RE: DRAINAGE PLAN FOR BLANKLEY GALLERY  
(J-13/D34) ENGINEER'S STAMP DATED OCTOBER 29, 1986

RE: DRAINAGE PLAN - BLANKLEY GALLERY ( J-13/D34 )

RE: DRAINAGE PLAN FOR BLANKLEY GALLERY  
(J-13/D34) RECEIVED OCTOBER 14, 1986

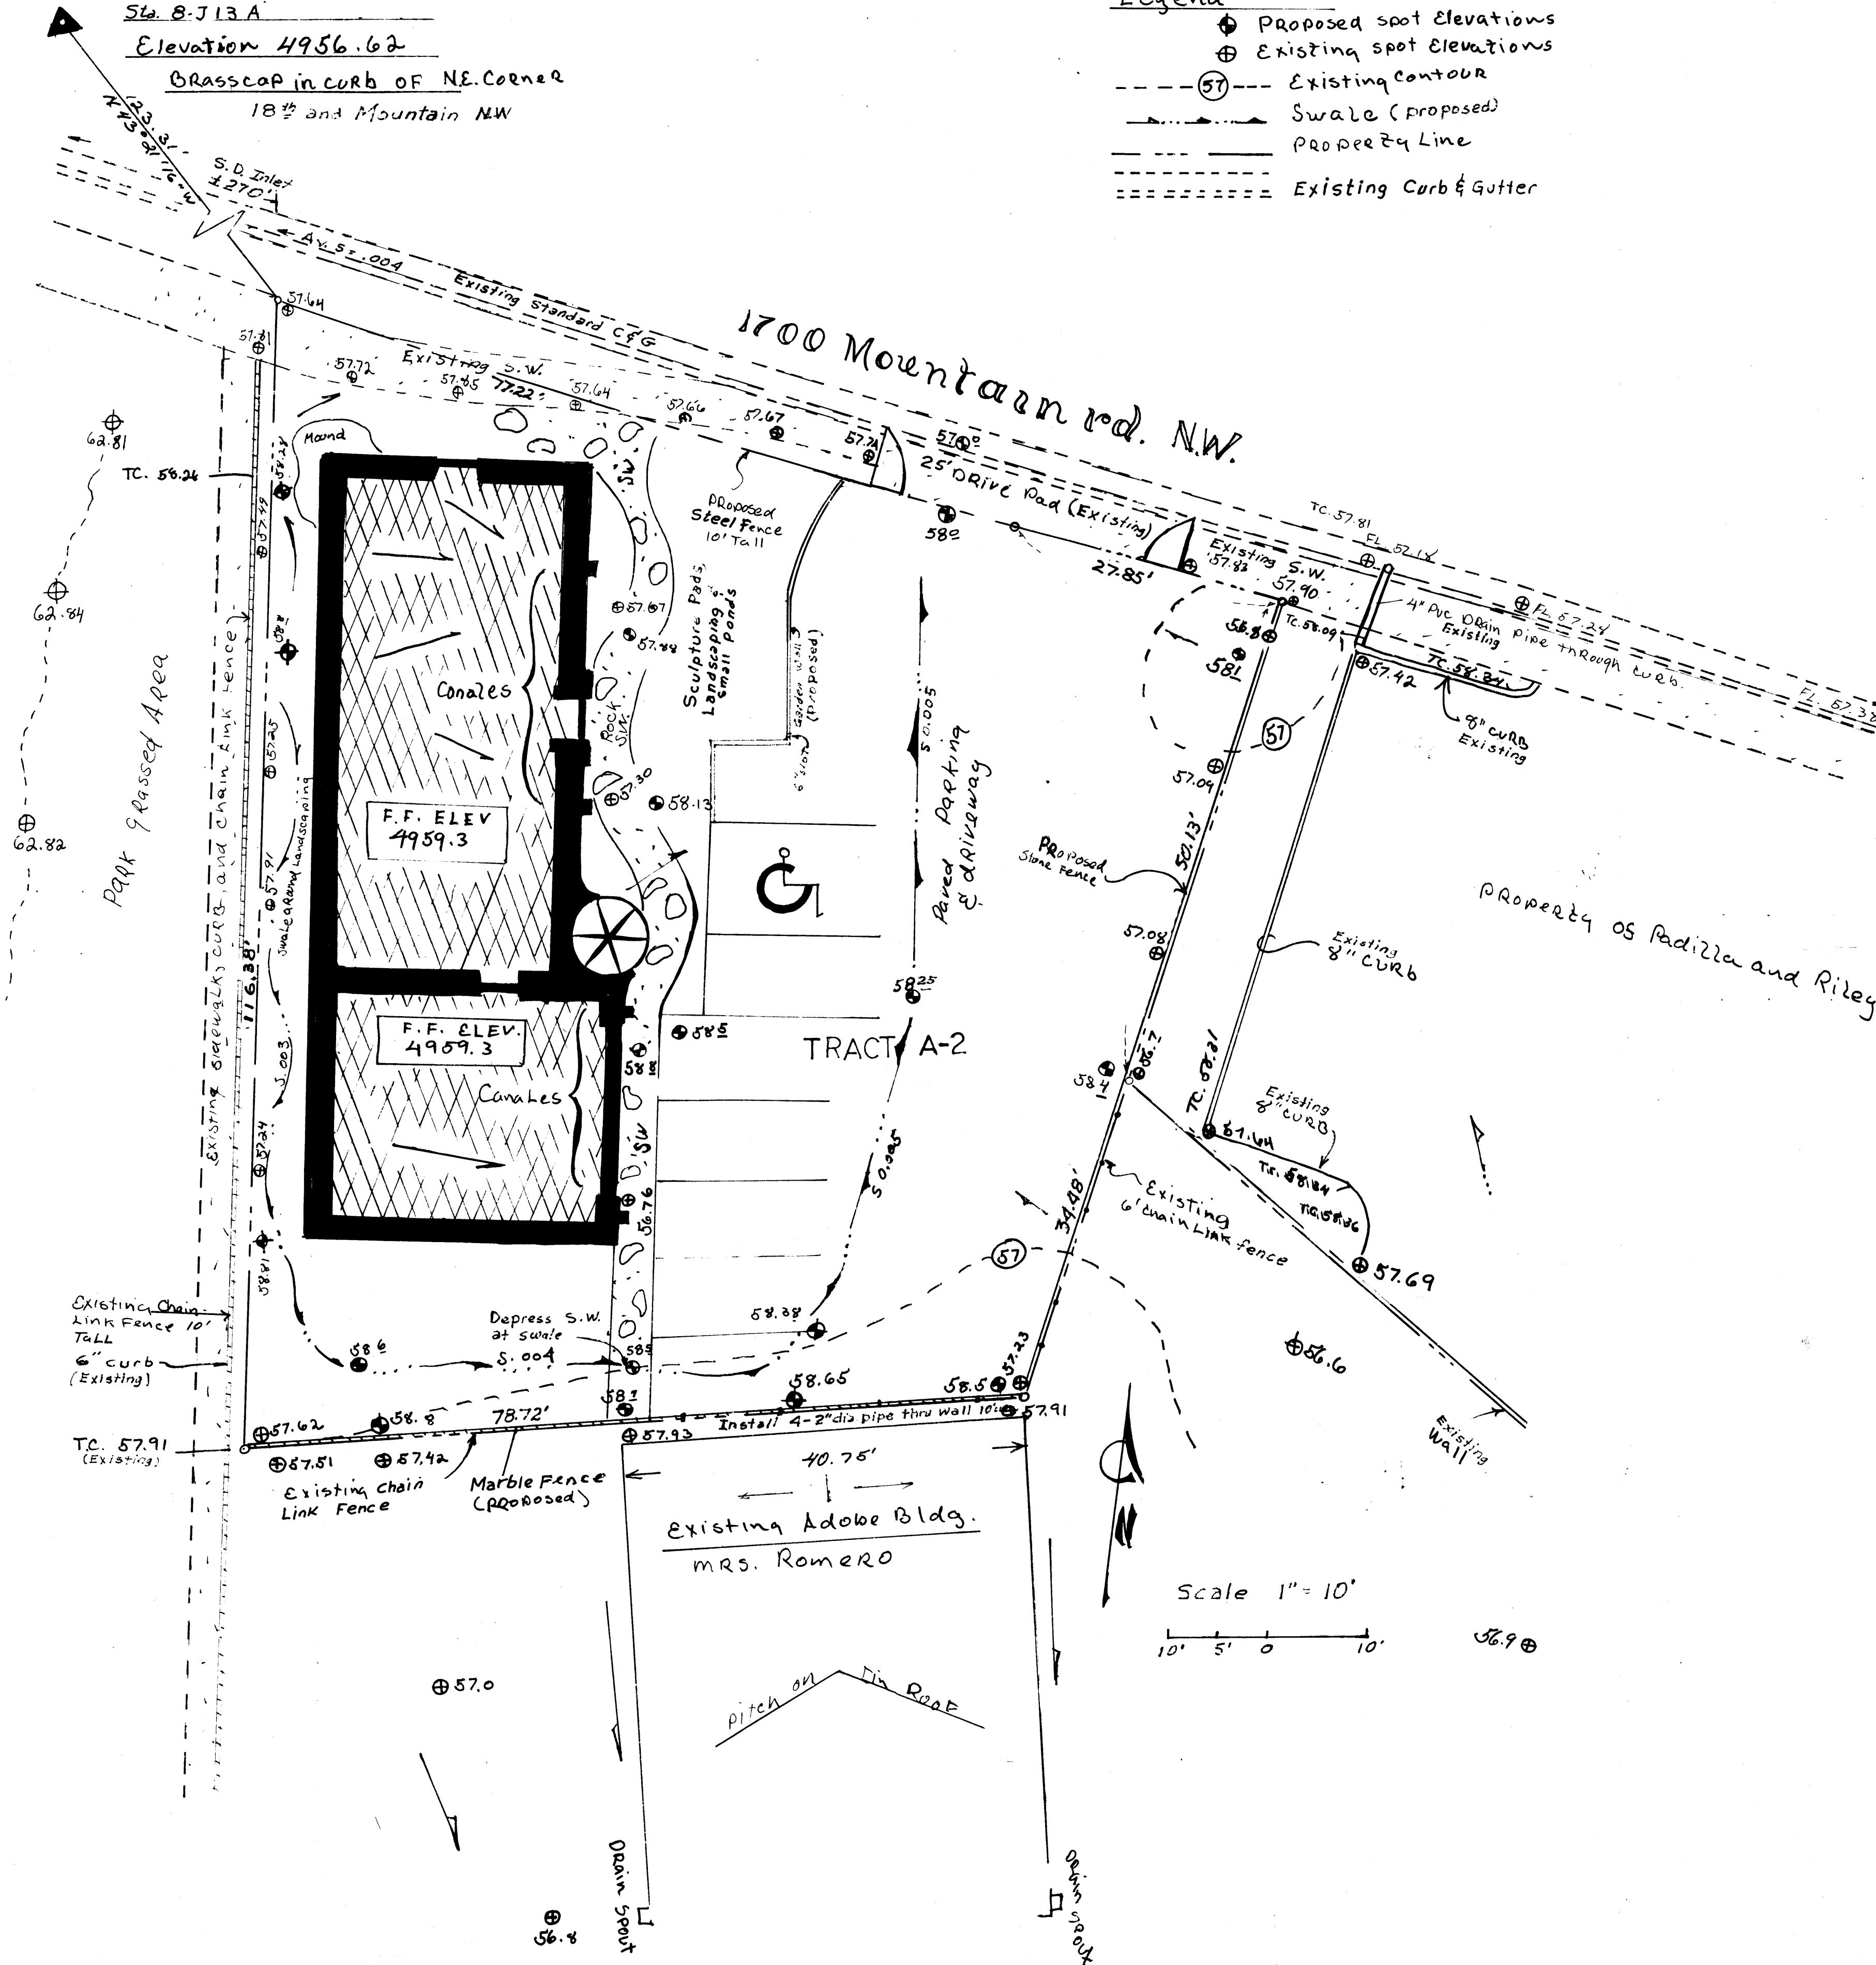
1. Drainage across lot lines will require easements, replat, or covenants before Building Permit is released.

1. Unable to determine what is proposed and what is existing. Please address (for instance, the 4" PVC pipe through the sidewalk or the 8" curb).
2. Location, description and elevation of TBM.

1. Drainage across lot lines is not planned at this site and therefor drainage easements are not needed. Runoff within the lot will drain toward the swale and to Mountain Road. *Has been replatted*
- ✓ 2. Additional "existing" labels have been added to the drawing to help clarify existing and planned improvements. Everything, shown on the drawing, on adjacent lots is existing.
- ✓ 3. The existing Albuquerque bench mark at the corner of 18<sup>th</sup> Street and Mountain Road N.W. is close enough to the site and it will be used as the site benchmark. The Location, description, and elevation has been added on the drawing along the right side.
